Our ref: CE/2011/104852/03-L01

Your ref: 3/2011/0480

Date: 18 November 2011

**PROPOSED DETACHED GRANNY ANNEX
SHUTTLEWORTH FARM, HENTHORN ROAD, CLITHEROE**

DATE: 10 DEC 10
DWG NO. ML/RW/4911
SCALE: 1:500
A2

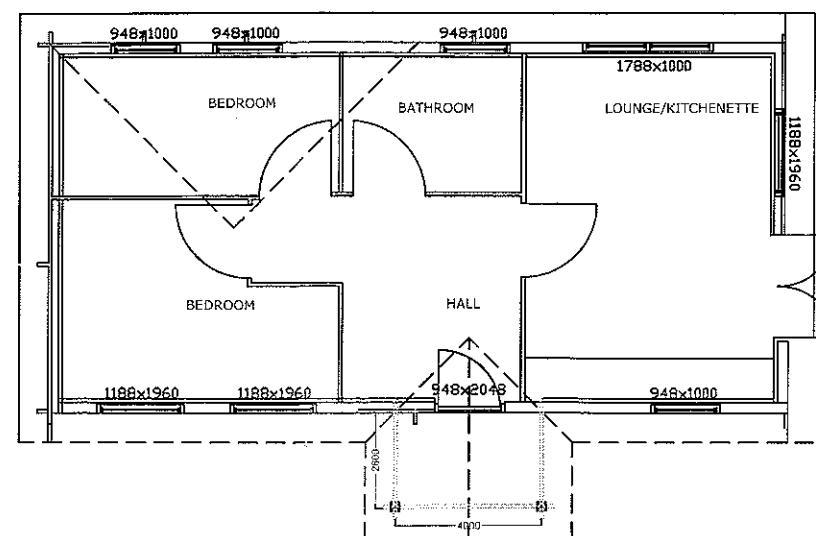
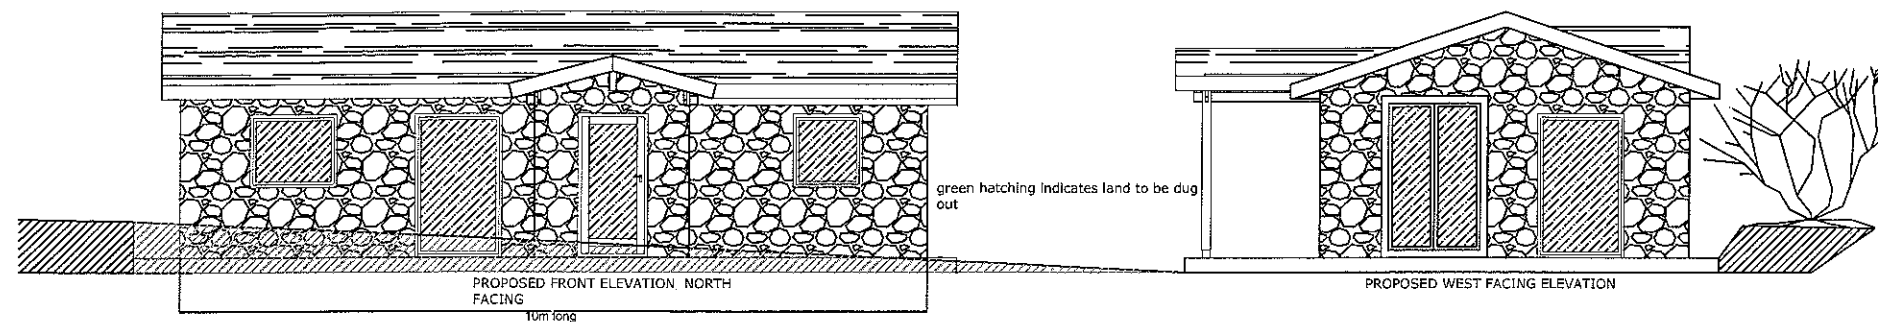
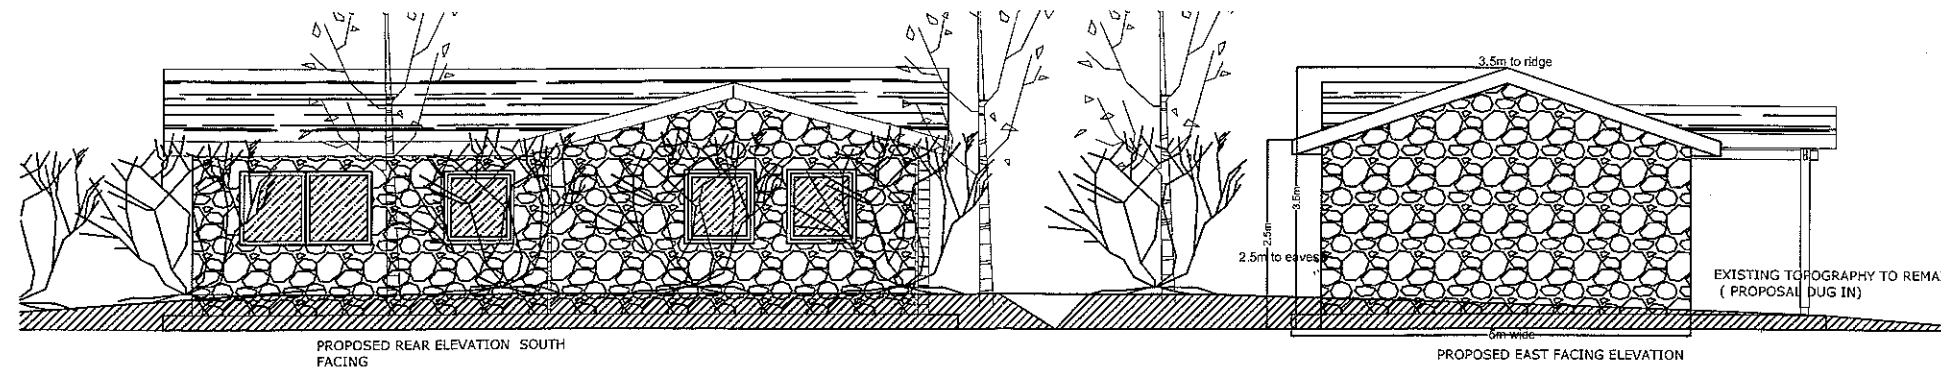
The revised plan (dated 13/11/11) shows that the ground floor level of the proposed annex will be set 300mm above the ground floor level of the existing farmhouse and **we withdraw our objection** to the proposed development. We recommend that any subsequent approval is conditioned as follows:-

Although the ground floor levels will be raised to afford occupants some protection, the annex is still at risk of flooding during an extreme event and we would recommend the use of appropriate flood proofing measures. These include barriers on ground floor doors, windows and access points and bringing in electrical services into the building at a high level so that plugs are located above possible flood levels.

CONDITION The ground floor level of the proposed building shall be set at 46.61 metres Above Ordnance Datum
